Our Ref: EP/94/18/HH
Your Ref:

Town & Country Planning Act 1990 (as amended)
Town & country Planning (Development Management Procedure) (England) Order 2015
Application for Planning Permission for Works or Extension to a Dwelling

Development Single storey rear extension
Location 107 Roundstone Drive East Preston

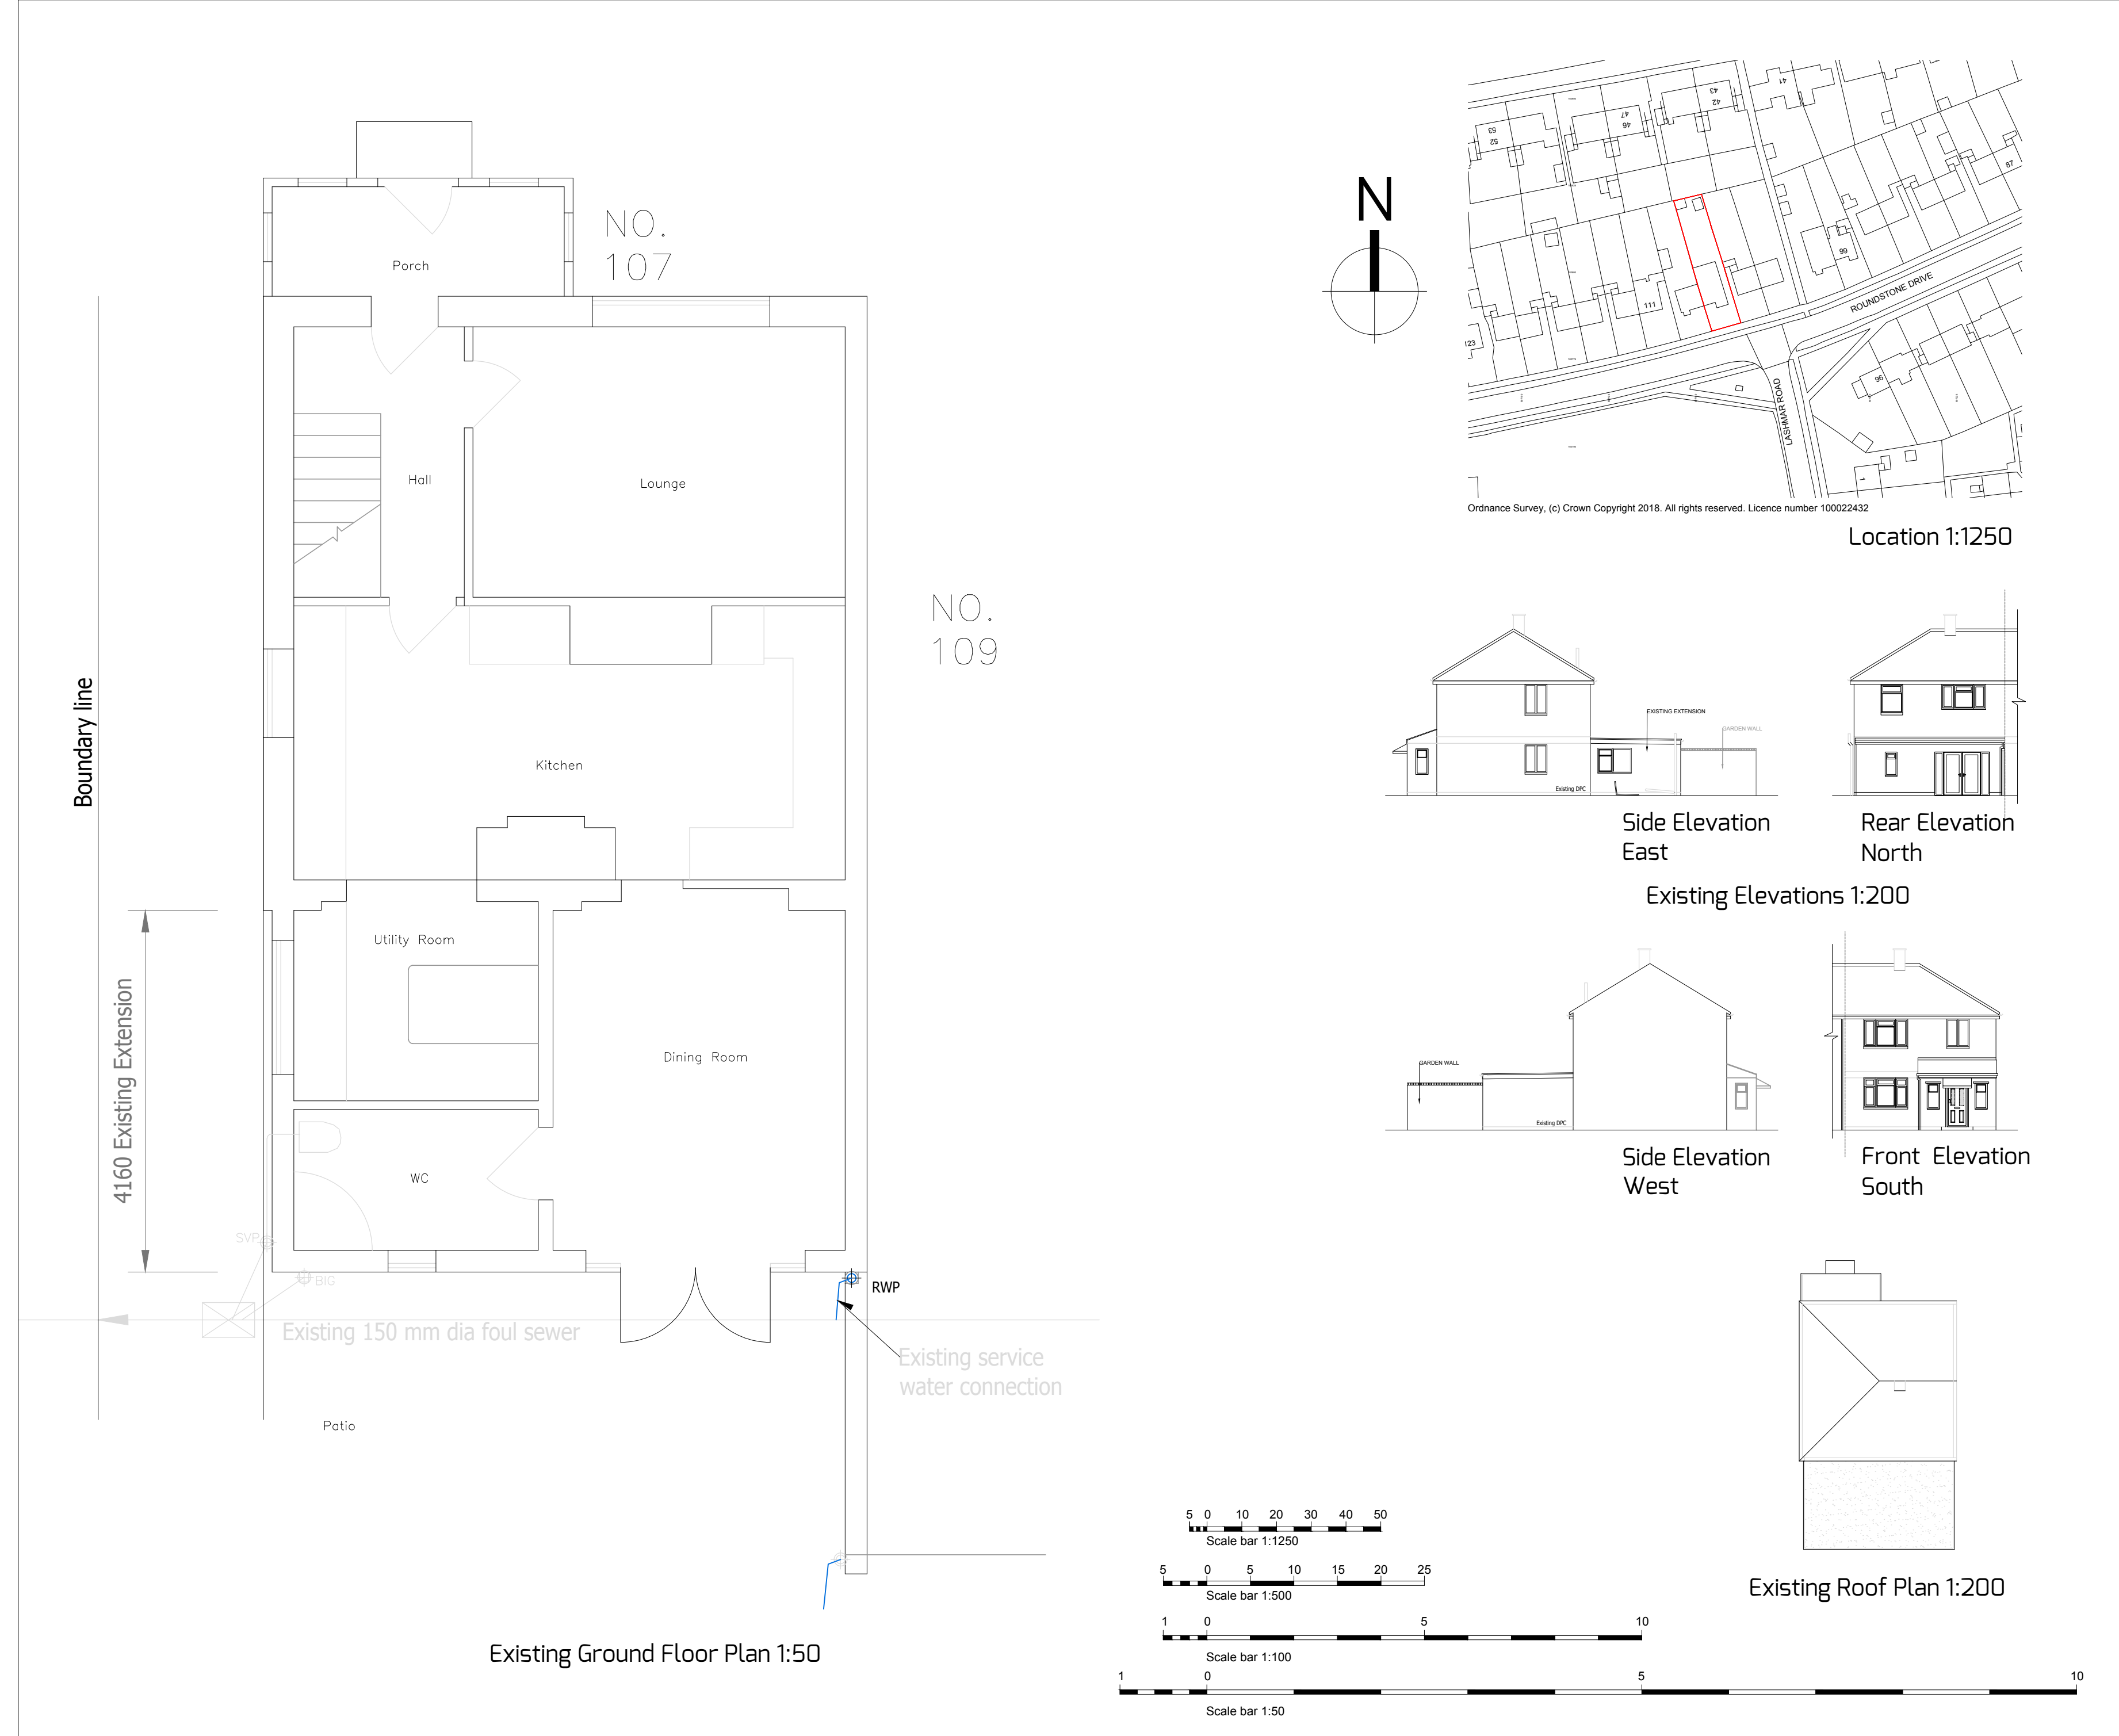
Two elevations (existing and proposed) have been labelled as rear. Please amend accordingly.
